At this stage we **would not recommend discharge of conditions** until the following comments are addressed.

PROPOSED FEATURES

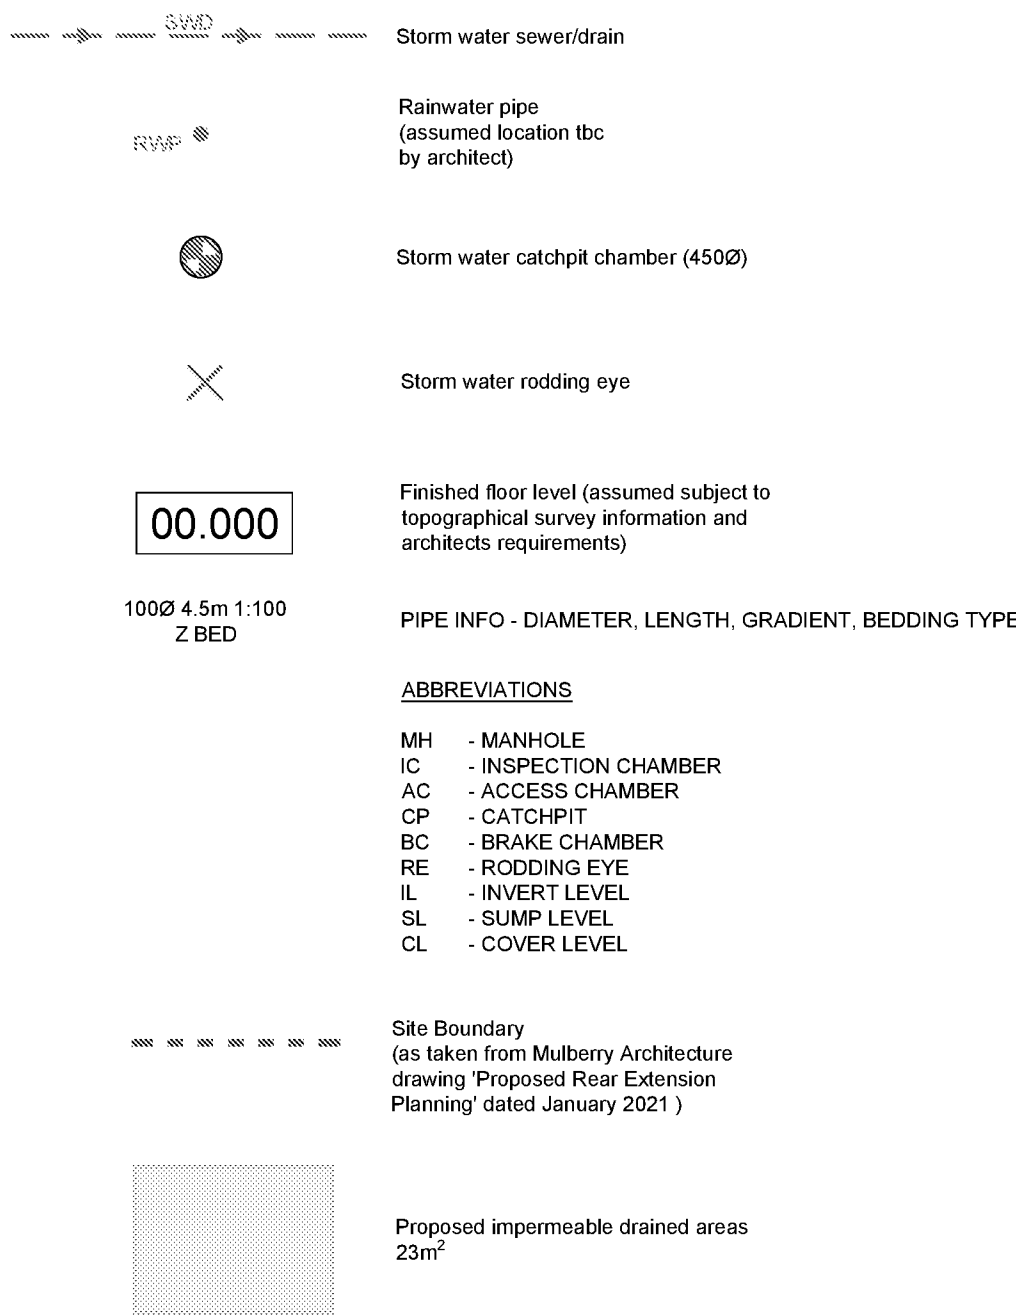
1. Additional information is required on the design drawings.
 - The loading class for the cover on the sediment trap manhole (and any other manholes) should be stated.

- The access point for carrying out maintenance and inspection of the soakaway should be stated, (and details given if this is an additional element of the design e.g. additional manhole).

4. The incoming pipe invert level is potentially below the 1:10 year water level within the soakaway. The applicant should confirm that the pipe is not likely to be surcharged during the 1:10 year storm. Or the pipe could be raised to provide a larger difference between the soakaways invert level and the pipe inlet invert level, or additional crates included within the design, to lower the 1:10 year water level.

5. The applicant should confirm that the soakaway is outside of the root protection zone (RPZ) for the trees located on the land where the soakaway is proposed.
